Document DCO 8.3B/MCO 8.3B

Statement of Common Ground between the Applicants and North West Leicestershire District Council (relating to Planning Policy)

June 2026

The East Midlands Gateway Phase 2
and Highway Order 202X and The East Midlands Gateway
Rail Freight and Highway (Amendment) Order 202X

Drawing Title
**ILLUSTRATIVE
LANDSCAPE
MASTERPLAN**

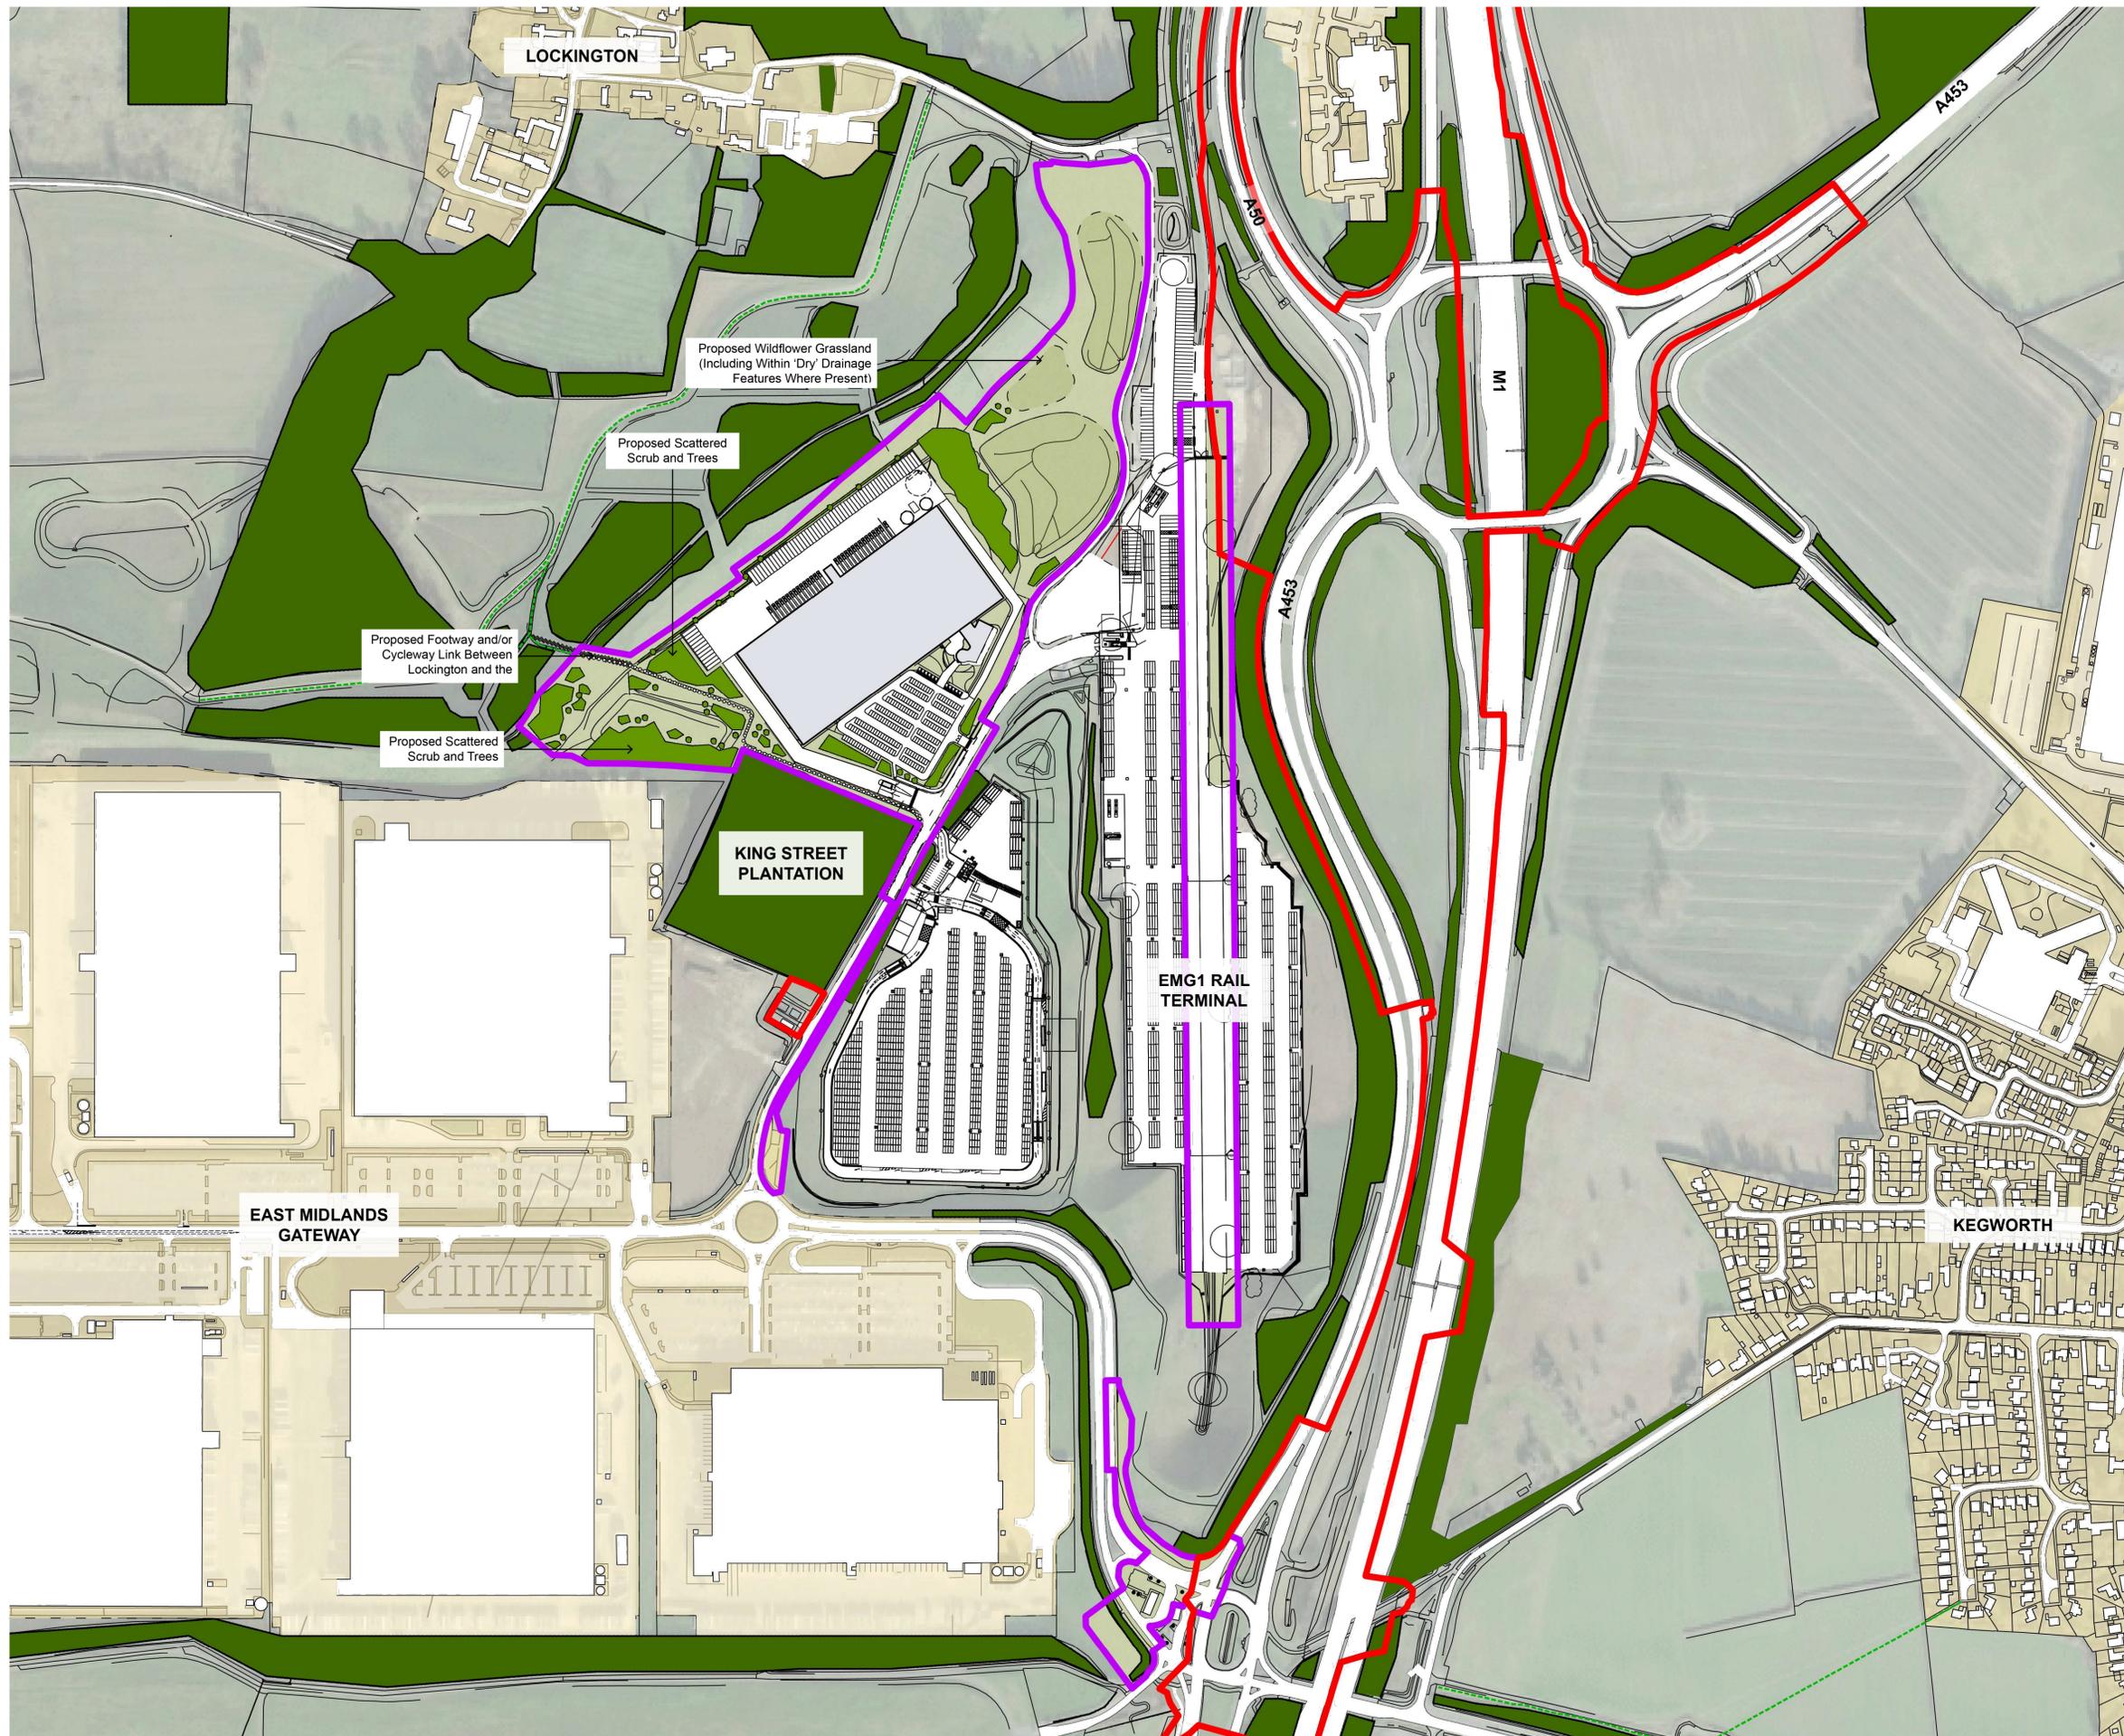
4.13	Landscaping along A453 frontage	<p>DCO Parameters Plan (Reference AS-006D)</p> <p>DCO Illustrative Landscape Masterplan (Reference AS-048)</p>	<p>It is the applicant's position that the proposed screening along the A453, as shown on the Parameters Plan and Illustrative Masterplan is robust and appropriate.</p>	<p>NWLDC has noted the Applicants response to Q2.0.6 of the First Written Questions of the ExP (Reference REP1-054) in that an acoustic fence is only required to the site boundary with the A453 if the service yard associated with any unit adjacent to the A453 is presented to the A453 (rather than internally into the site).</p> <p>Notwithstanding this, the DCO Parameters Plan and DCO Illustrative Landscape Masterplan do not show land which may potentially be safeguarded for the dualling of the A453 and how this may impact on the landscape buffer to be provided. Additionally, the Applicants did not provide a response to the ExP in relation to the 'minimum' width of the landscape buffer alongside the A453 as was specified within Q2.0.6.</p>	Under Discussion

NWLDC would require details to be provided in relation to the above points before such time as comments can be provided on the suitability of the landscaping alongside the A453 site frontage.		
--	--	--	--	---	--	--
